PLANNING AMENDMENT

Application No. *H20/1234/97*
 Date Registered *06 FEB 1998*
 Case Officer *DK*

*Conversion of barn
 to 4 bed dwelling*

Description: Conversion of barn to four
bedroom residential dwelling
and garage.

NAME	MR. P. ADAMS.	
DETAIL	REVISED WINDOW DETAIL AND ARCH.	
SCALE	1:10	DATE MARCH 98

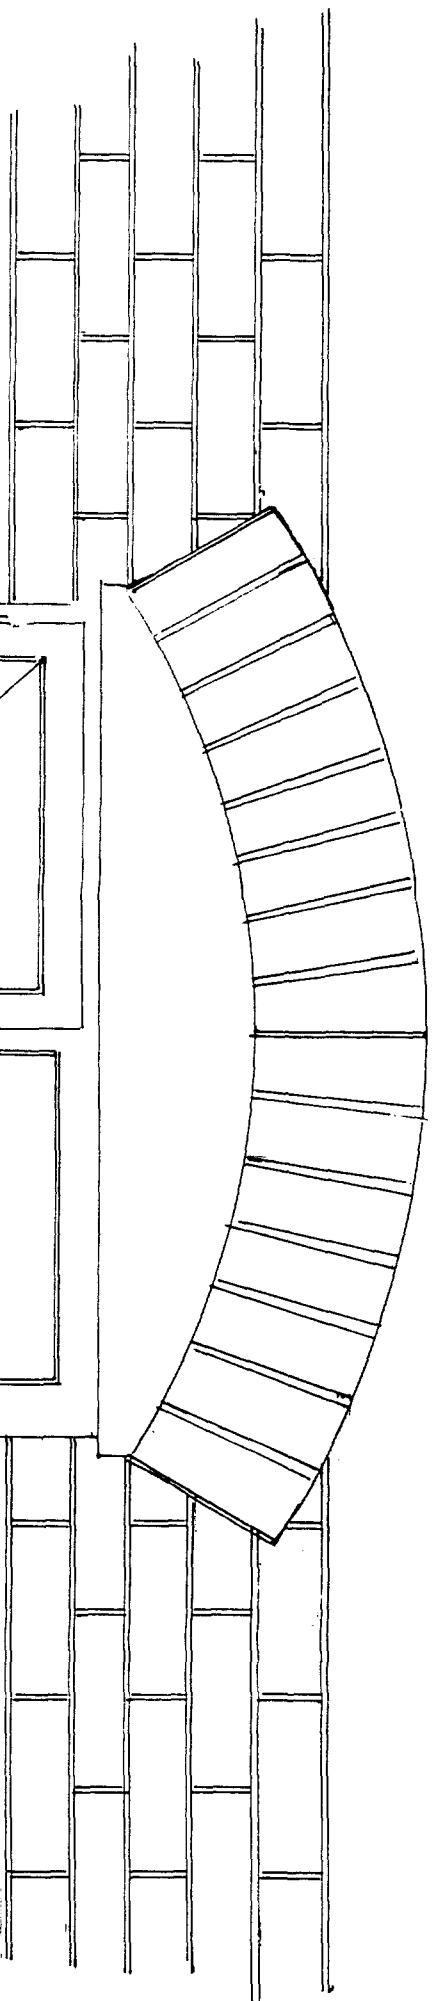
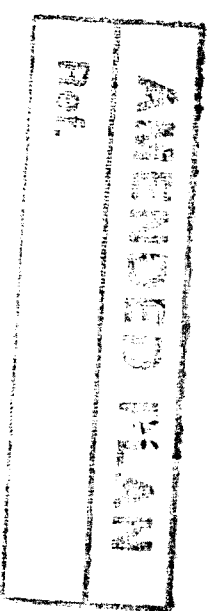
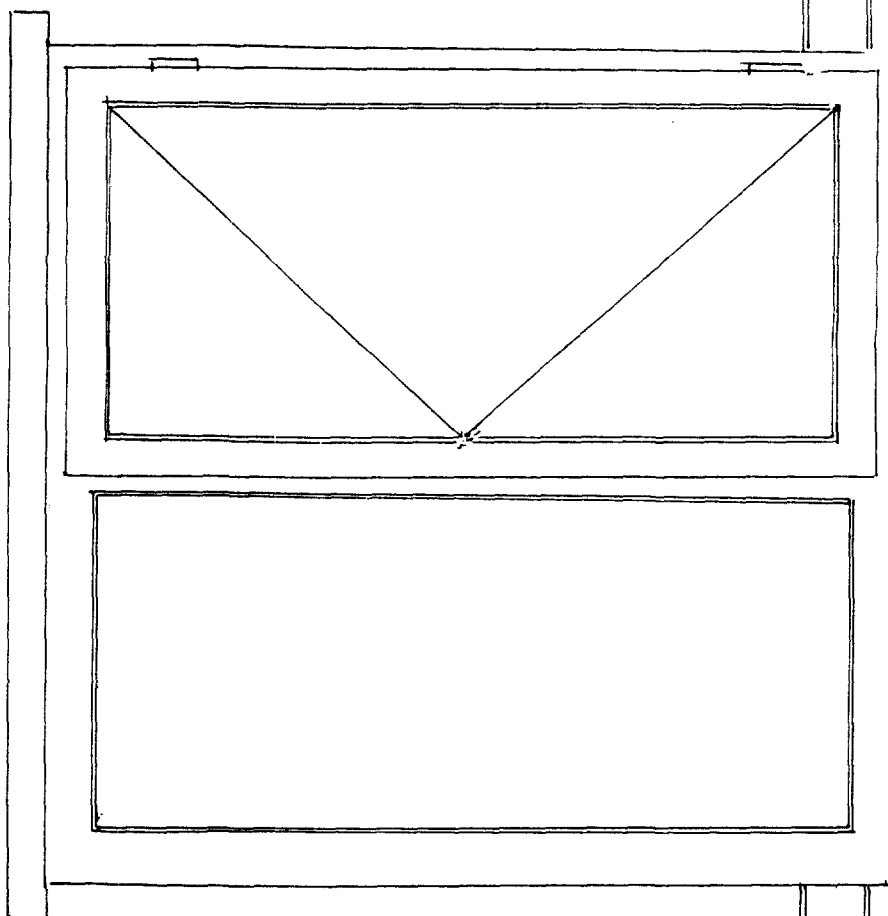
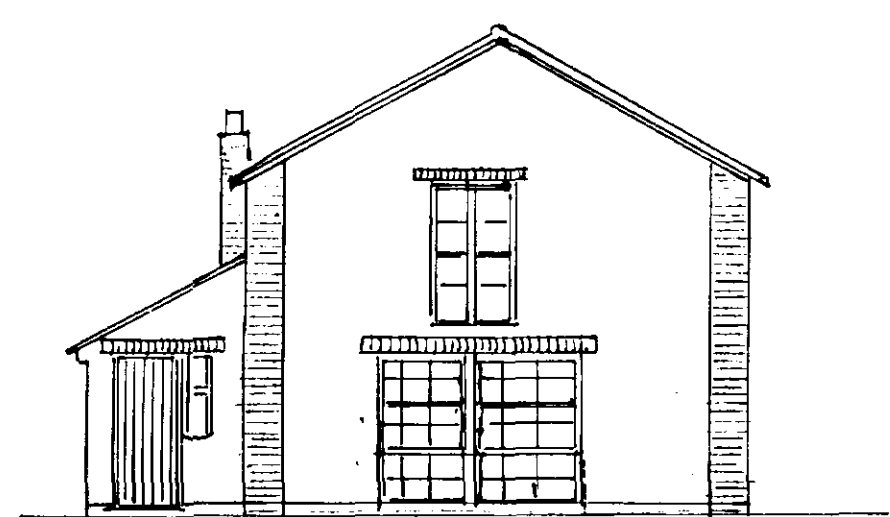
Timber casement
windows with vertical
central bar with
arched head

Amendment: Timber casement windows with vertical central bar with
arched head

FRONT ELEVATION (WEST) 1:100

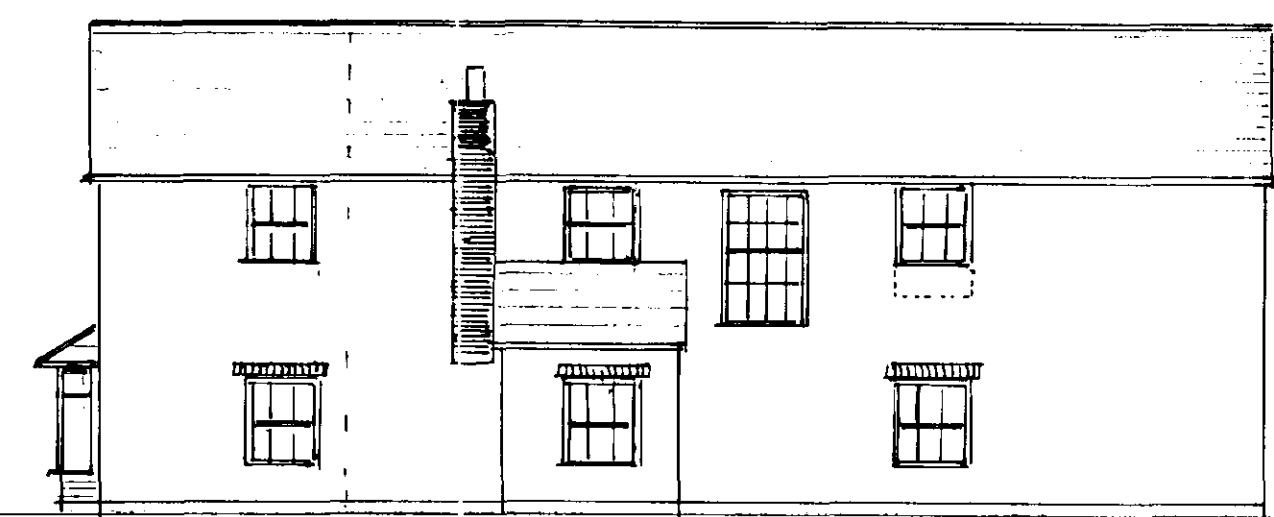
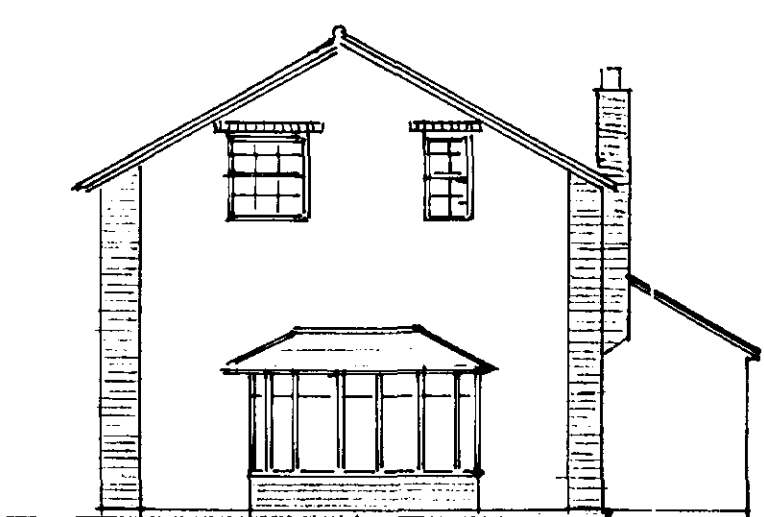
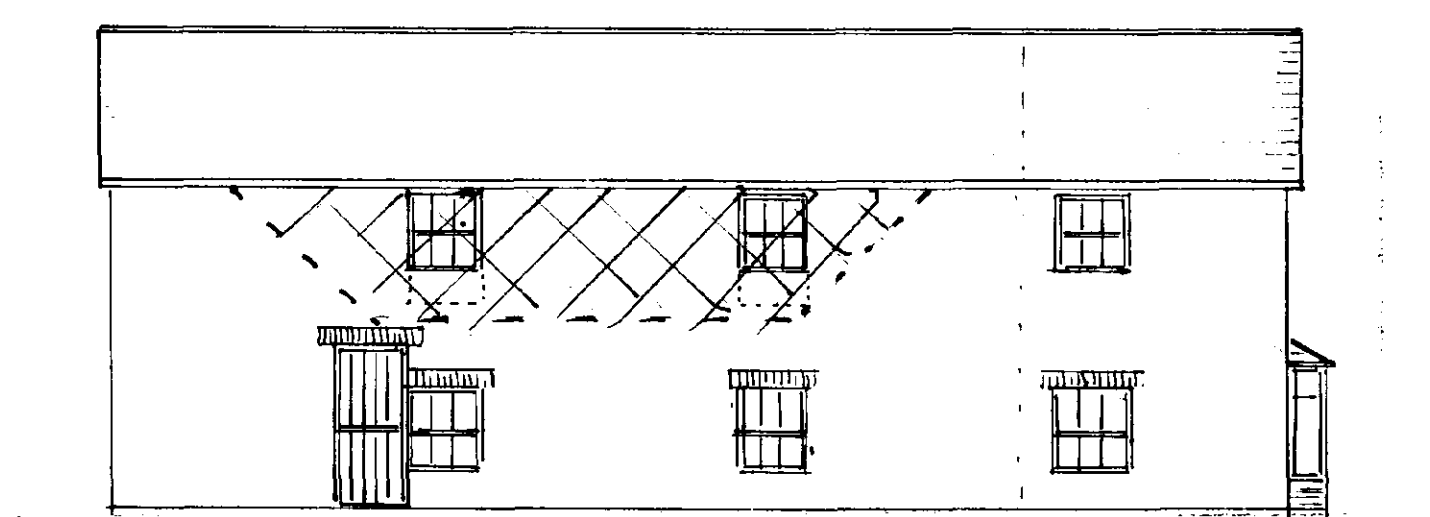
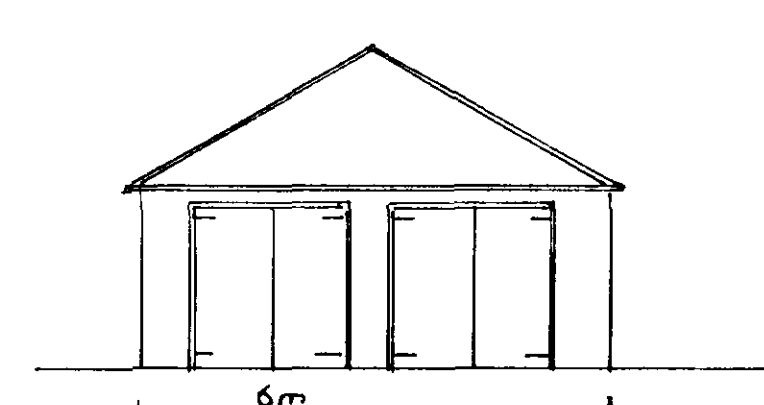
Alterations to elevations.

Amendment: Alterations to elevations
